**Application Number 2020/92307/ Penistone Road/Rowley Lane Fenay Bridge HD8 0JS
– Outline Application of Residential Development (Land now forming part of HS2)**

Green Alert in Lepton (GAIL) is recognised by the Council as a non-statutory consultee and representative of the Local Community on matters relating to the Local Plan. This further consultation response is submitted on behalf of GAIL following the recent submission by the applicant of additional/revised information in support of their application.

1.0 Design and Access Statement id 85903

Weaknesses:

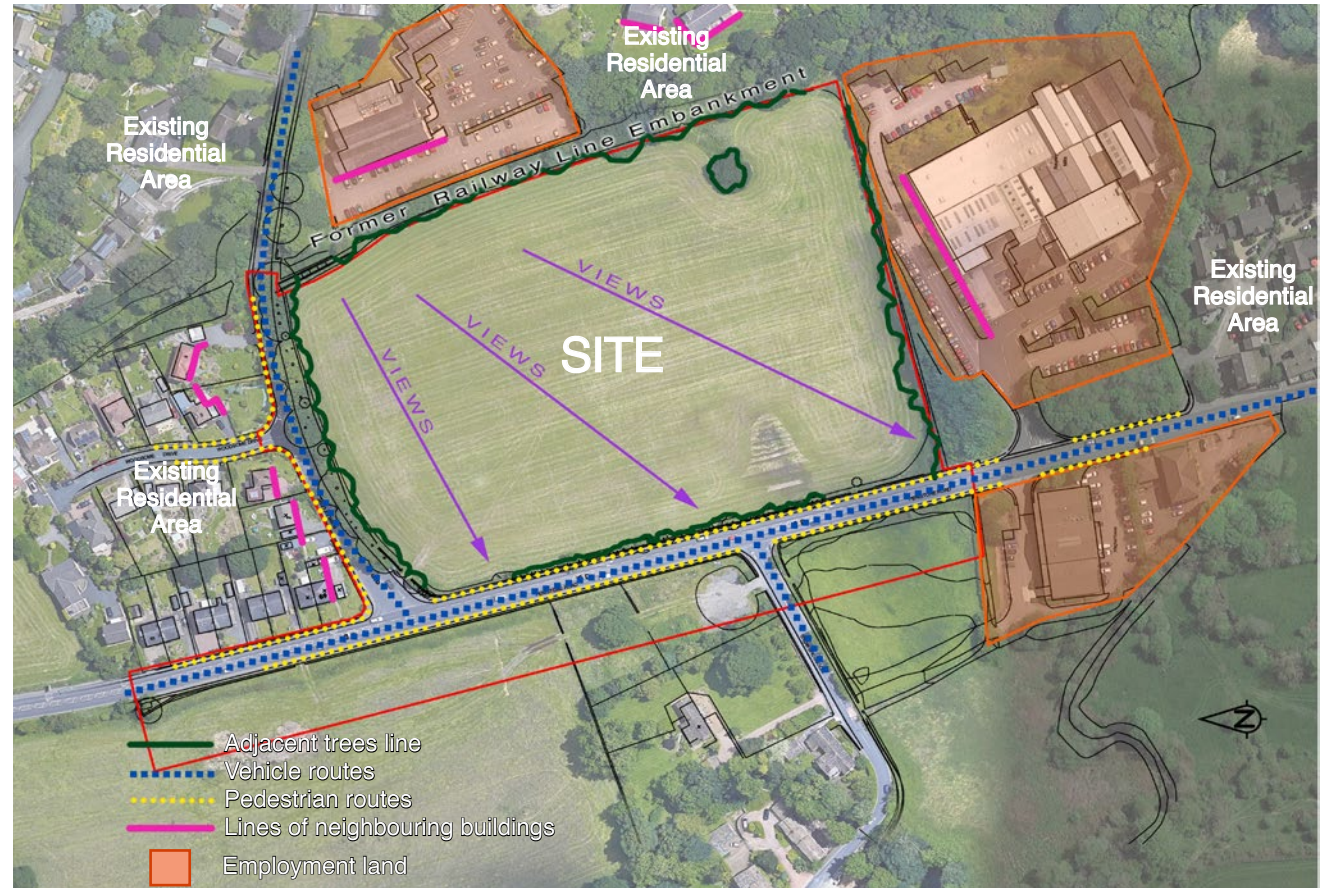
1.15 The SWOT analysis fails to mention as a weakness the considerable impact this development will have on both Woodsome Hall and on 1 Woodsome Road. GAIL has commented below regarding 1 Woodsome Road and previously on Woodsome Hall.

Peninstone Road and Rowley Lane junction

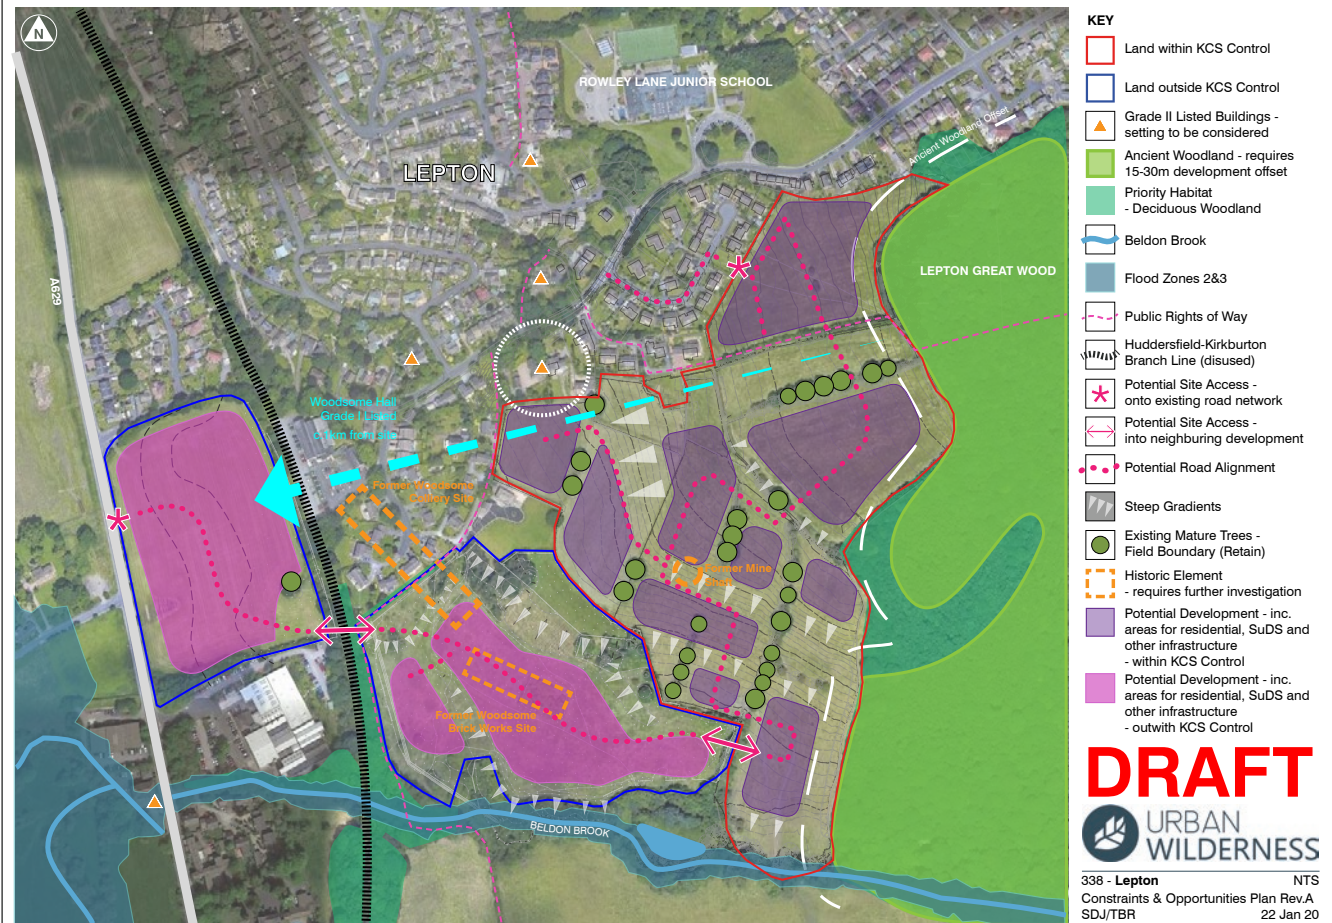
1.9 Interestingly the Design and Access Statement (id818935) at paragraph 2.9 Site Photographs shows a single Transit Van waiting at the Rowley Lane/Penistone Road junction. It can only be assumed that this was taken on a Sunday at the height of the Corona virus lockdown as it is far from reality, is quite deceptive and can only be intended to mislead.

1.10 Reality is shown below which represents a true picture of what this junction is like during rush hour periods with traffic queuing along Penistone Road waiting to turn right and traffic queuing way up Rowley Lane waiting to turn left or right .

**Figure 6: Viewsheds from points adjacent to 1 Woodsome Road**

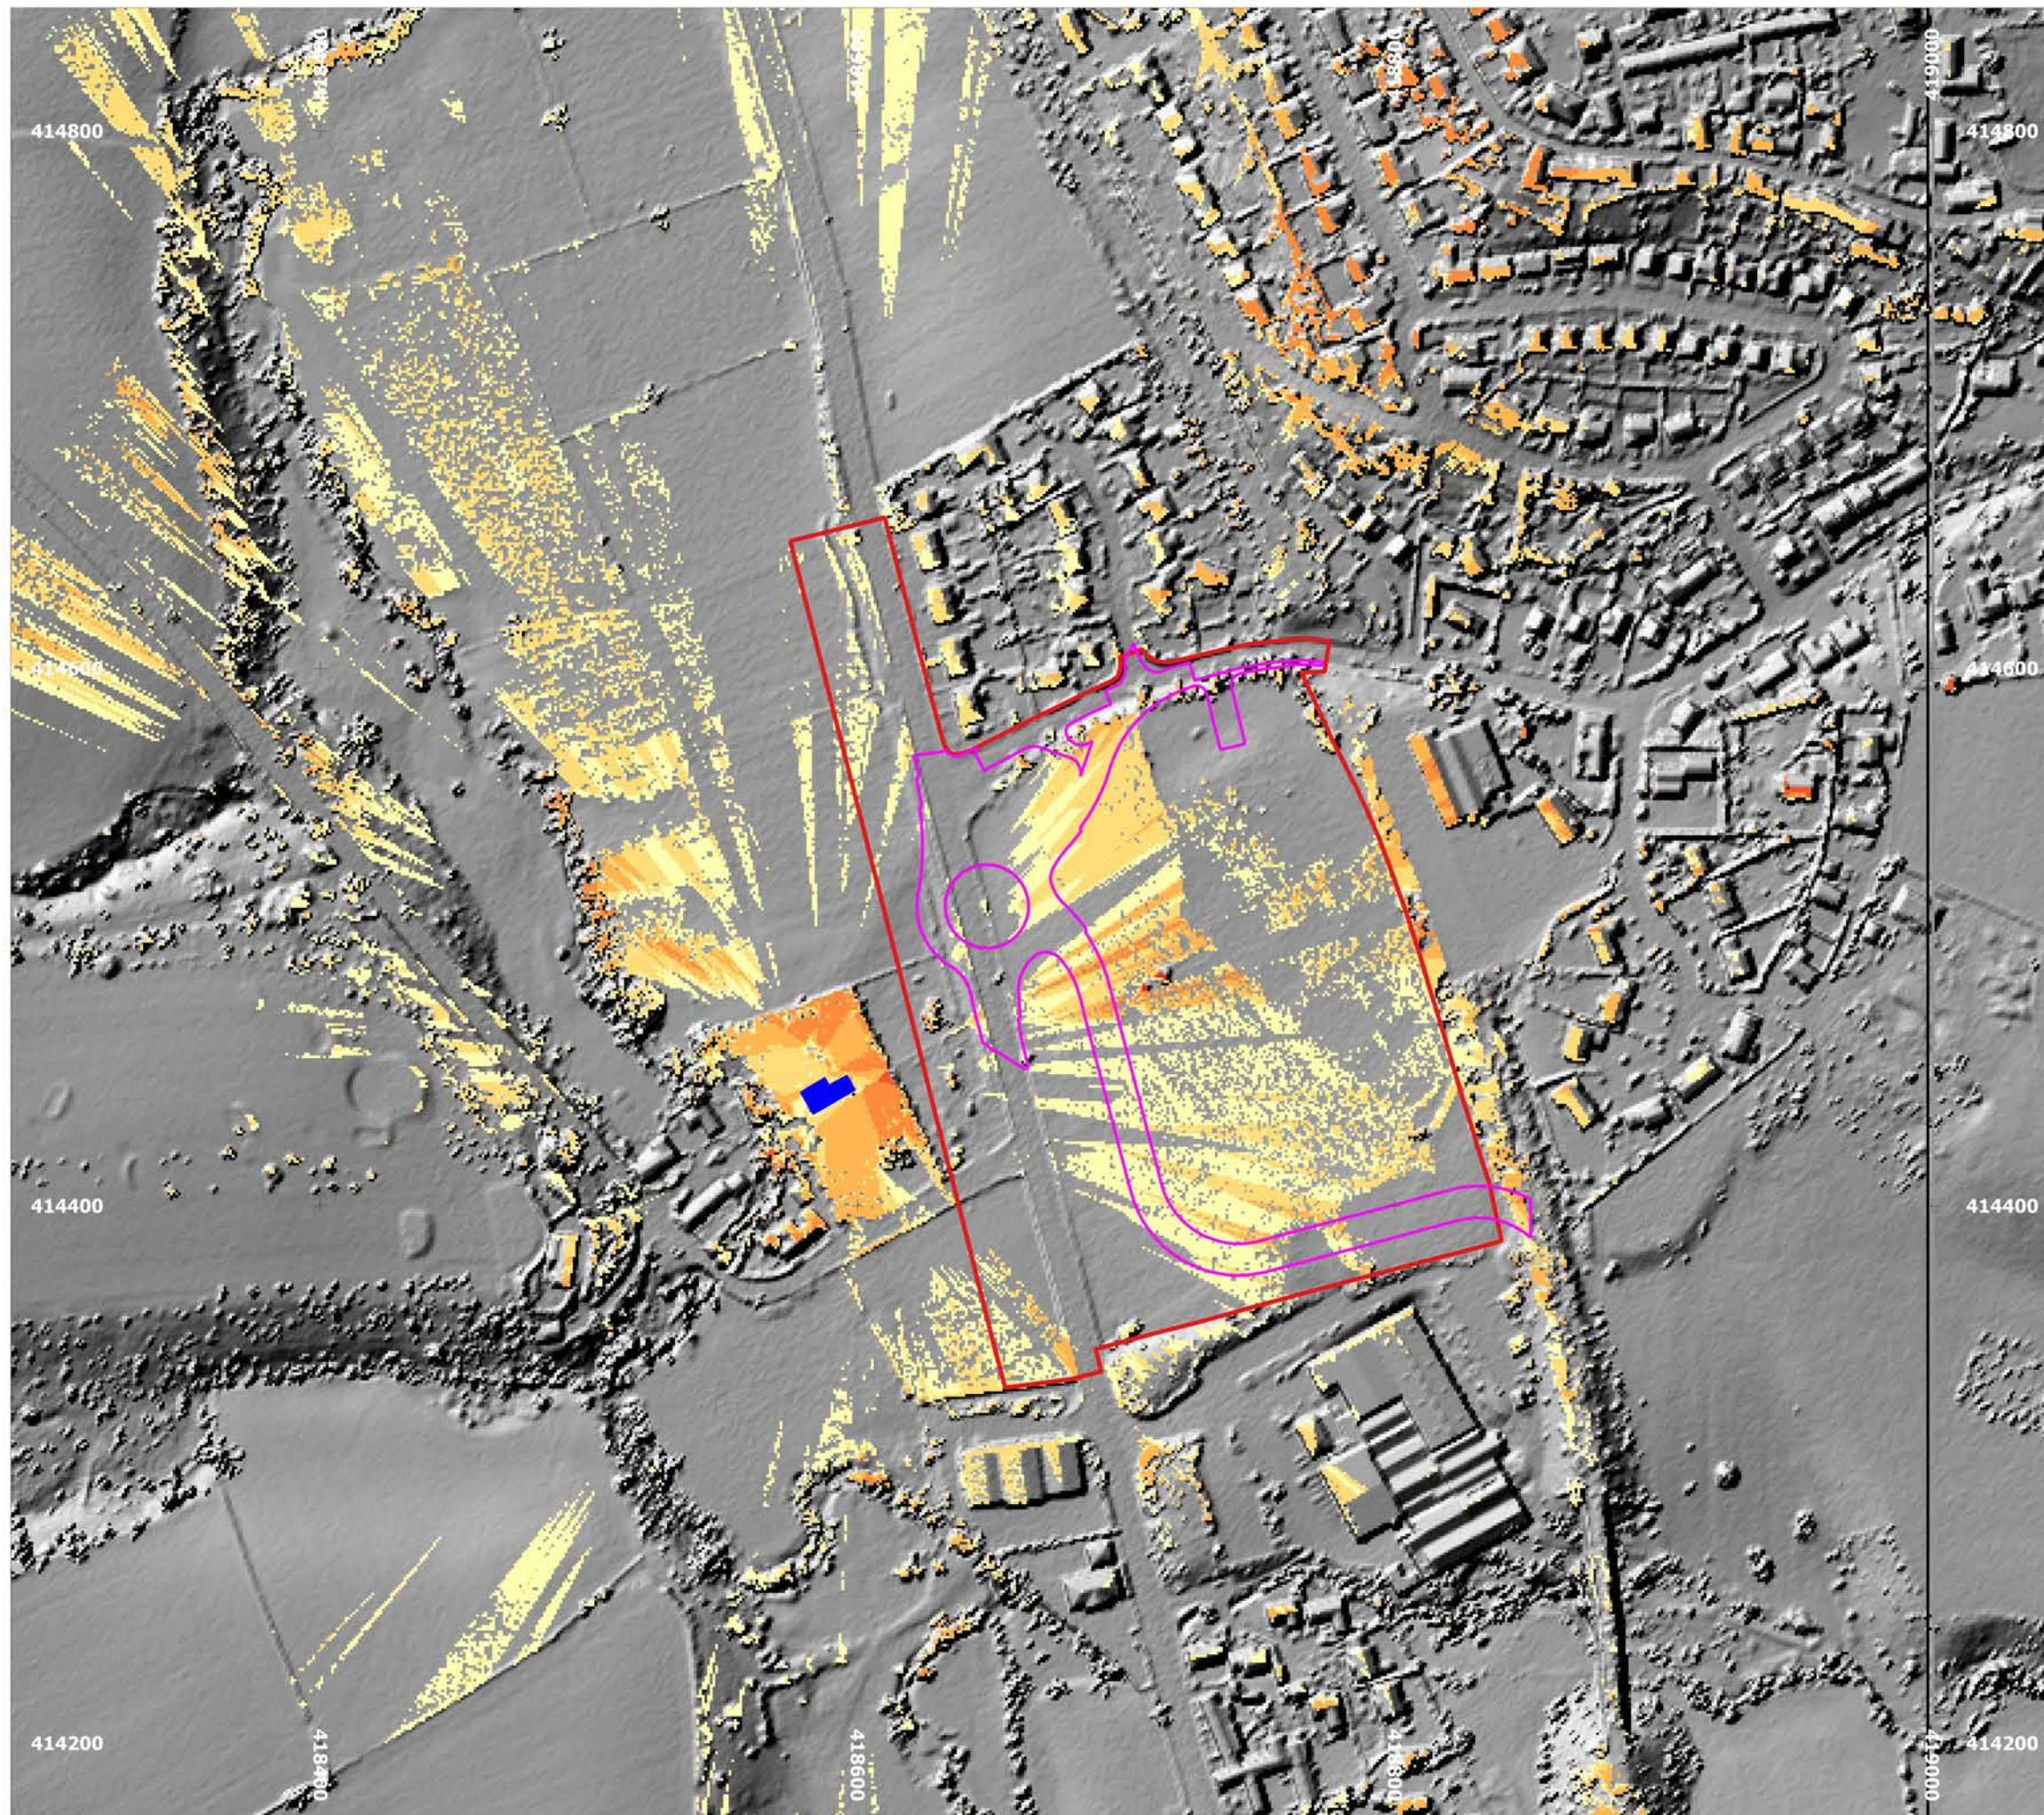
2.5 The main thrust of the report is to try to demonstrate that the asset and its setting will be unaffected by the proposed development. It goes on at length to try to justify why 1 Woodsome Road will not be affected by the Proposed Development Area (PDA) but makes little more than a passing reference to the impact on the setting of the listed asset from the proposed realignment of Penistone Road and the installation of a new roundabout with associated lighting.

2.6 The report suggests that for the months when the trees are in leaf there will be 'glimpsed views of the PDA and slight adverse effects' This may be the case but by extension this means that for the months when the trees are not in leaf the views of the PDA and the realigned road and new roundabout will be unobstructed.

2.10 This is especially true given that the land proposed for construction of the new roundabout is some 2 mts lower than Penistone Rd and so will need to be built up resulting in the new roundabout and associated lighting being approximately level with the bedroom windows of 1 Woodsome Rd.

2.11 By encroaching into the adjacent field the new roundabout will be only approximately 35mts to 40 mts away from 1 Woodsome Road which represents a significant intrusion into the peaceful enjoyment of the property and must result in substantial harm to the setting.

2.12 ARS has mentioned the line of trees between the property and the road and roundabout. There is indeed a line of trees which are deciduous and so will not be in leaf for 6 months of the year leaving the roundabout and road clearly visible from the property. During the winter months especially there is also a significant risk from light pollution.

HS2

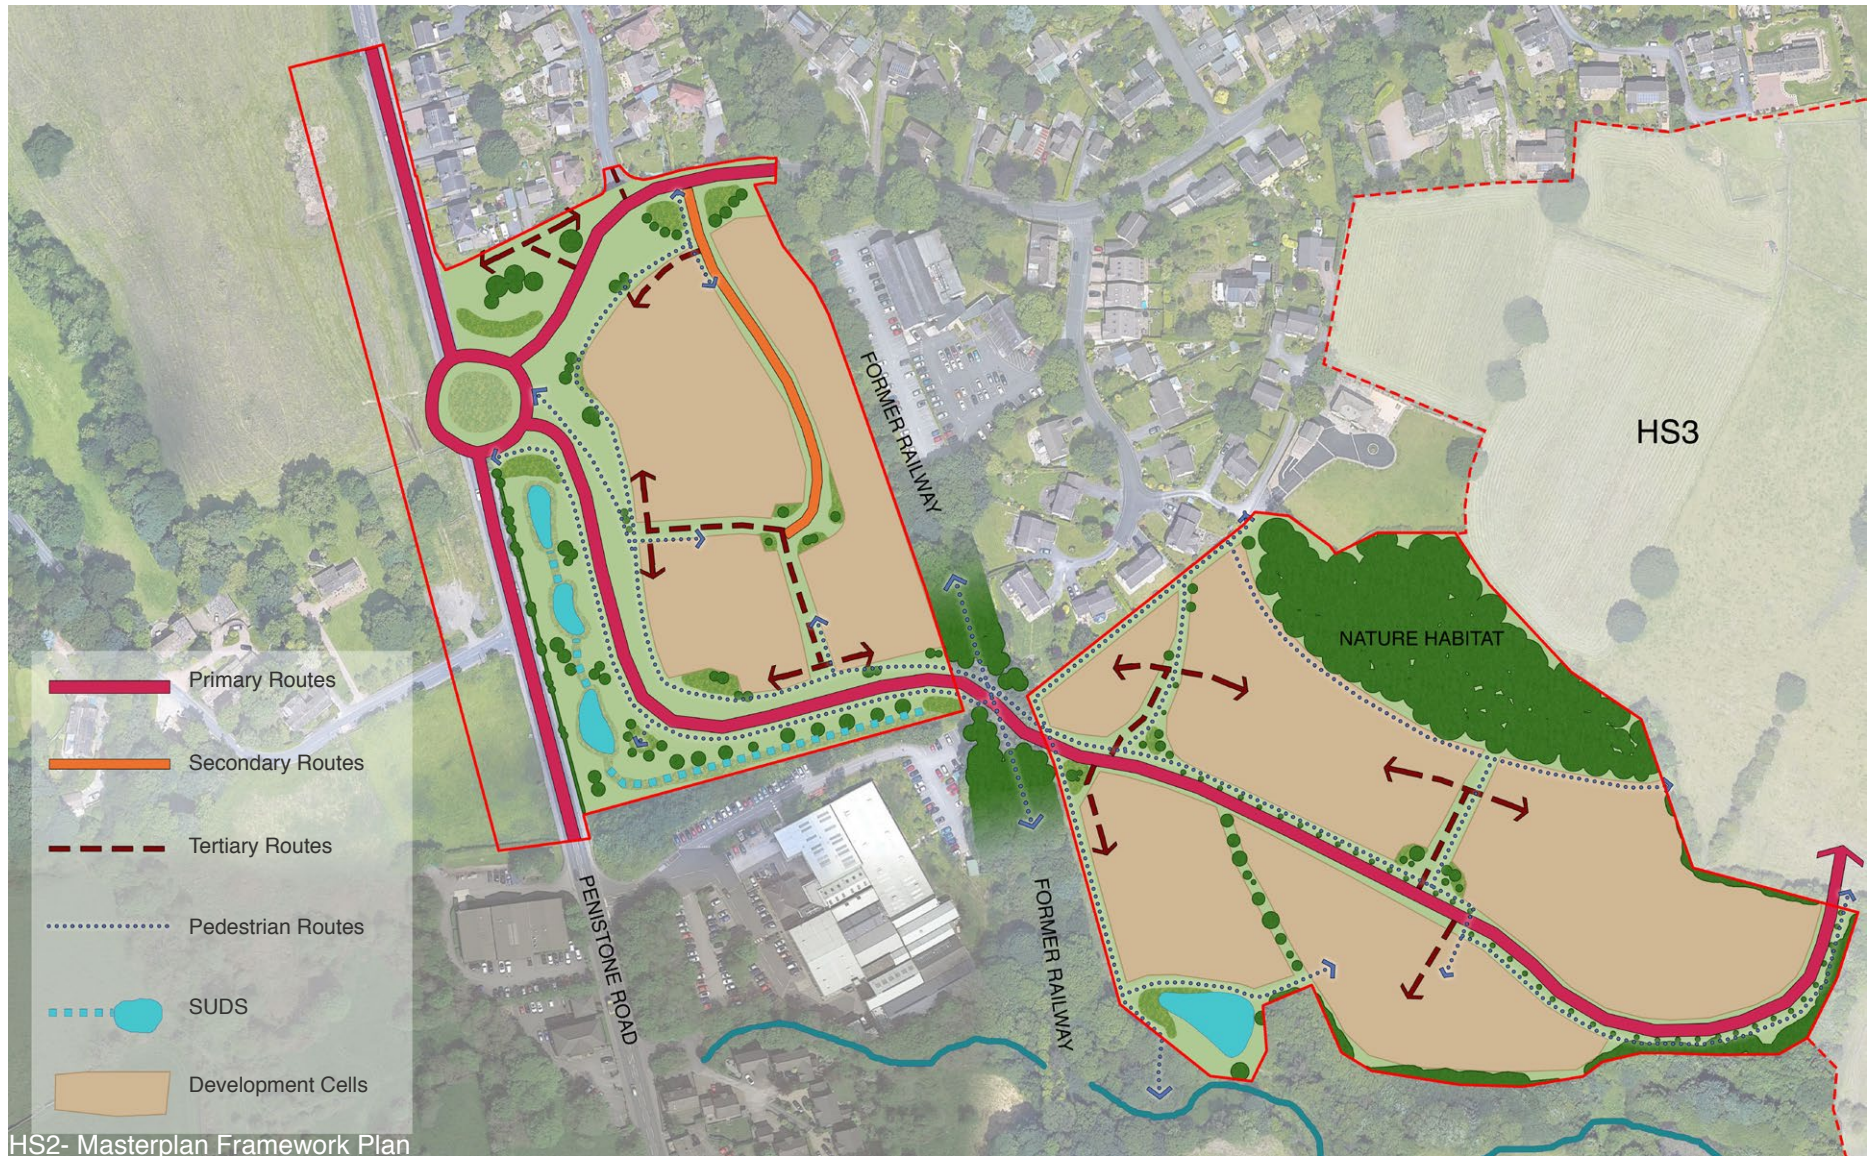
1.16 The Masterplan contained within the Design and Access statement is silent on how this development will conserve and enhance the natural environment which is a serious omission given the nature of the land, the fact that it is adjacent to a UK BAP priority habitat and part of the Kirklees Wildlife Habitat Network.

2.7 The report does mention the Masterplan will be the means by which landscaping and planting etc will mitigate any harm to the setting. Examination of the Masterplan however gives no indication of any new landscaping treatment or new planting.
